Appeal Decision

Appeal Ref: APP/R4408/W/18/3204076

7 Burntwood Close, Thurnscoe, Rotherham S63 0QQ

- The appeal is made under section 78 of the Town and Country Planning Act 1990 (as amended) against a refusal to grant planning permission.
 - The appeal is made by Mr Scott Bodkin against the decision of Barnsley Metropolitan Borough Council.
 - The application Ref 2018/0245, dated 11 February 2018, was refused by notice dated 03 May 2018.
 - The development proposed is erection of detached garage with store above and erection of boundary fencing and demolition of existing garage.
-

prop. front view. 1:100m view from ex garage nos.

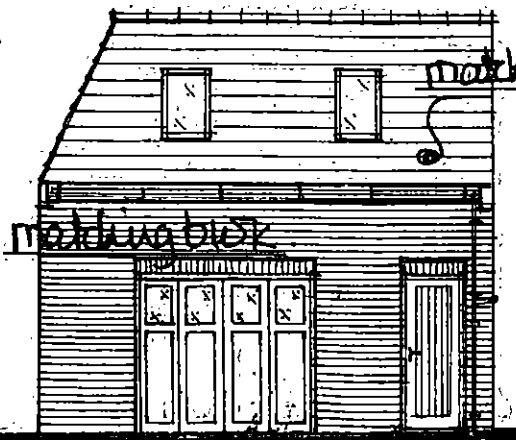
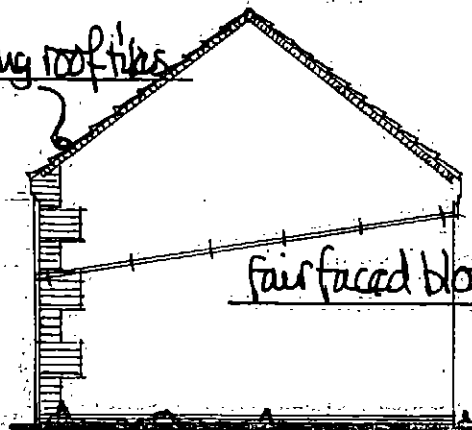
8. The Council is concerned over scale; the eaves and ridge heights of the proposed garage and store would be higher than those of the adjacent garage and the existing rear extension. Nevertheless, the appeal structure would be subordinate to the host dwelling and surrounding dwellings, and it would be viewed as a relatively small and separate building. Although it would be visible from the cul-de-sac which it adjoins and in the gaps between dwellings from neighbouring streets, it would not be a dominant structure in the streetscene. Furthermore, there is variety in the height and design of garages adjacent to each other at the head of neighbouring cul-de-sacs.

10. In its decision the Council says the proposed development would be harmful to the outlook of neighbouring properties from which it would be seen. The proposed development would not fully meet the guidance on separation distances contained in the SPD. However, the shortfall is not significant, and the proposed structure is relatively small. As a result, the proposed scheme

would not have an overbearing impact on the occupiers of neighbouring dwellings. I therefore find that the proposed scheme would not harm the living conditions of the occupiers of neighbouring dwellings having regard to outlook.
